Appeal Decision

Appeal Ref: APP/R5510/D/22/3301073

12 Dawley Avenue, Uxbridge UB8 3BS

PROPOSED LOFT PLAN

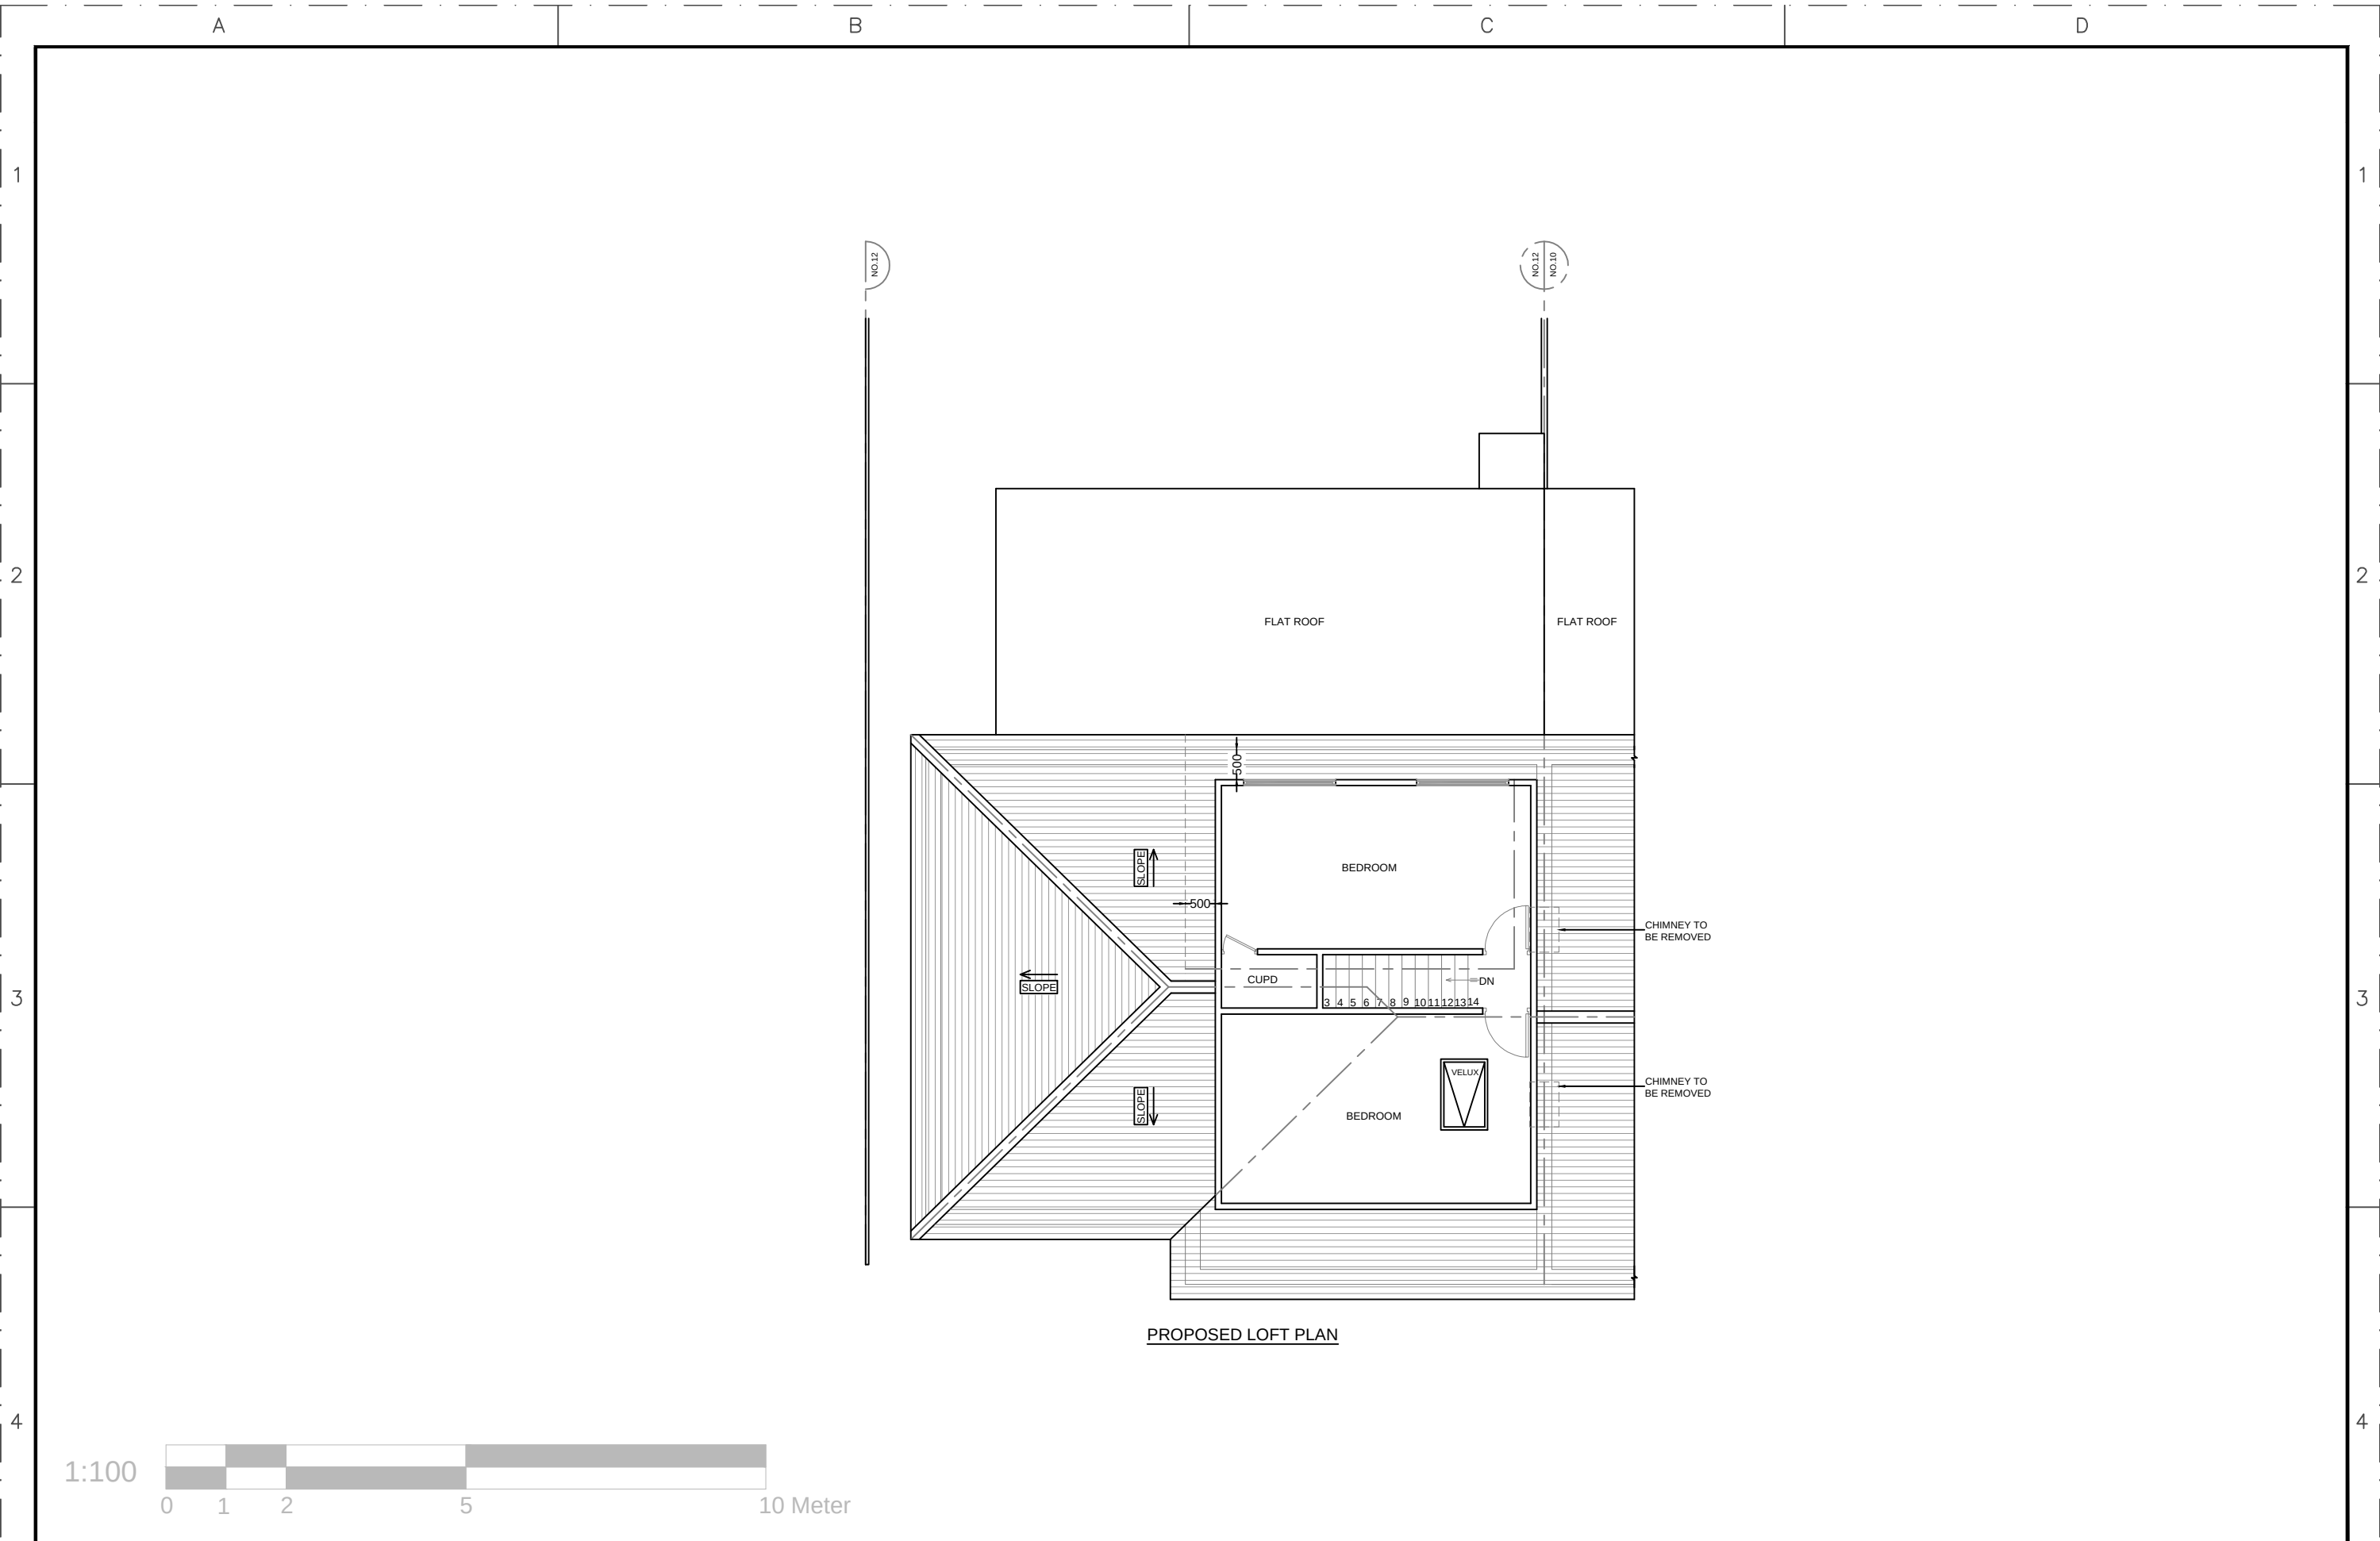
5. In addition, the rear dormer would be far wider than the original roof at second-floor level in conflict with Policy DMHD 1 of the LPP2 which states that roof extensions should not exceed more than two thirds the average width of the original roof. The appellant asserts that the dormer would be modest scale in comparison to the width of the proposed dwelling. Nevertheless and

notwithstanding the set back from the eaves and set in from the sides of the roof, the dormer could not in my judgement reasonably be described as subservient to the scale of the existing roof, and it would further add to the considerable increase in the overall bulk and mass of the building.

CLIENT/PROJECT	
12 DAWLEY AVENUE	
TITLE	ROOF PLANS

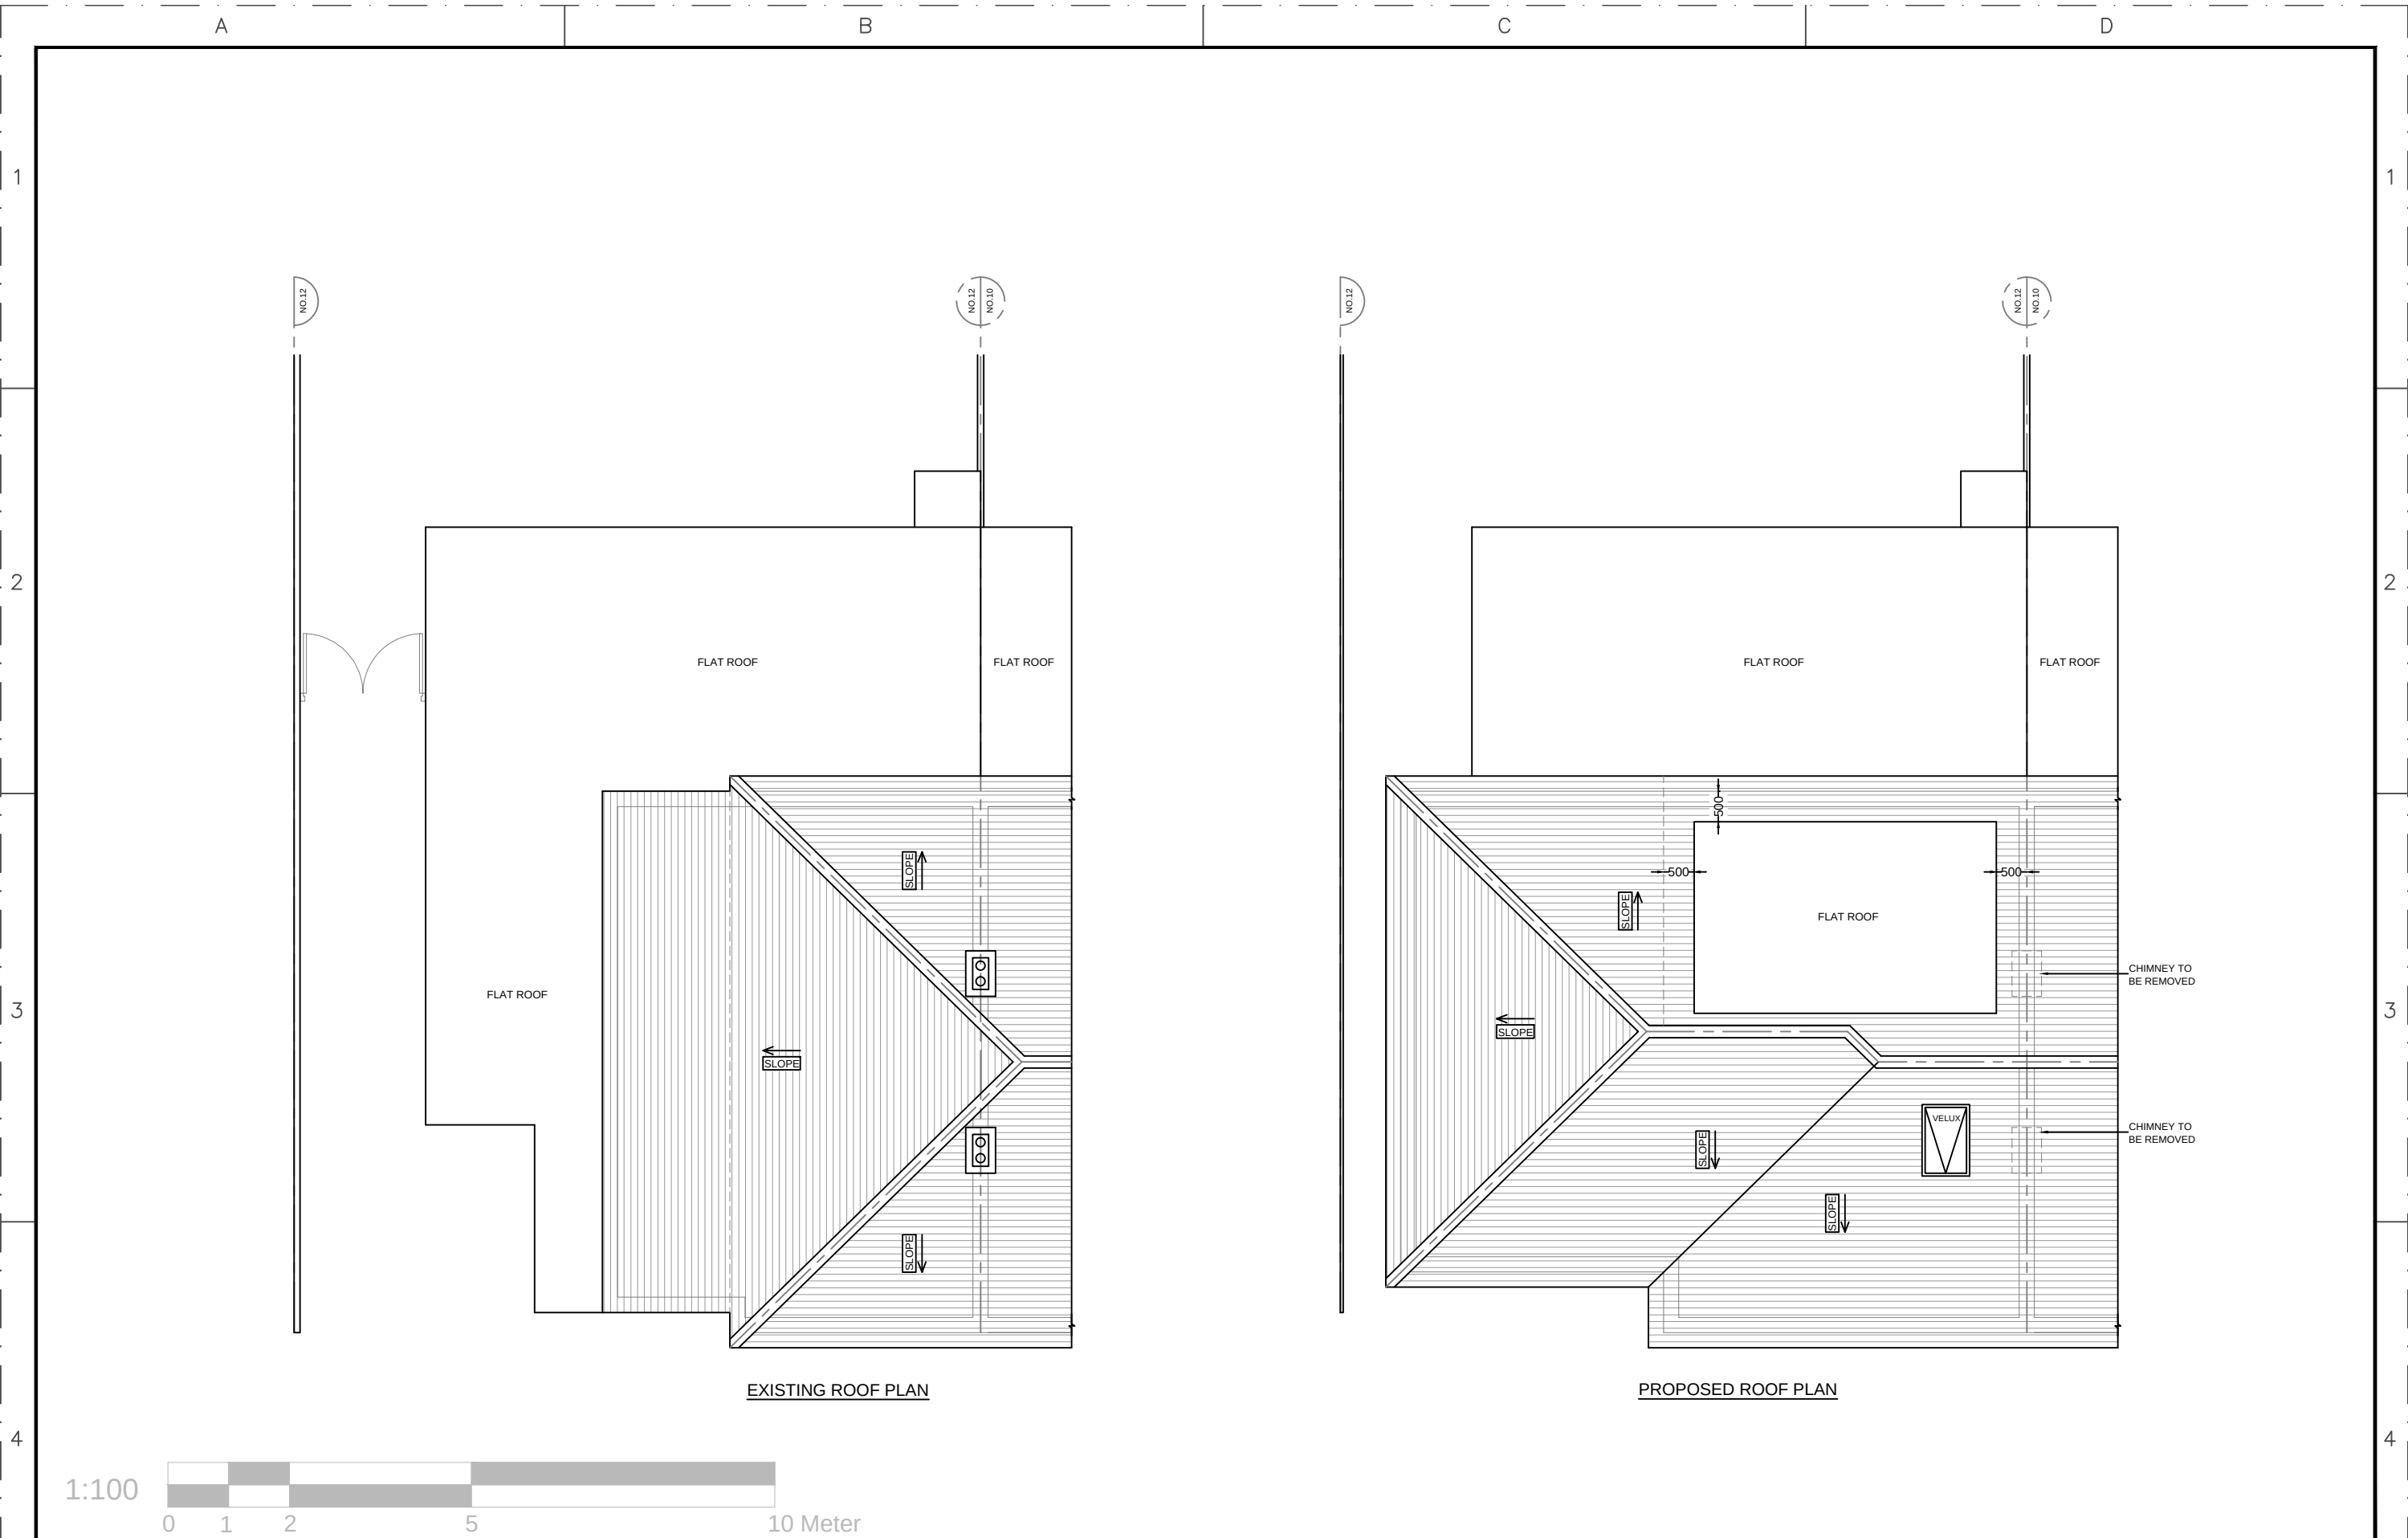
6. Taken together, I find that the dormer and side extension would result in oversized and disproportionate additions that would dominate and overwhelm the appeal building. Moreover, the proposal would result in the wholesale loss of the distinctive catslide roof to the side of the dwelling. In combination with the scale of the development proposed, this would undermine the character and integrity of the building on the appeal site, and the hipped roof over the side extension would stand out against the more typical catslide roofs to this part of Dawley Avenue.
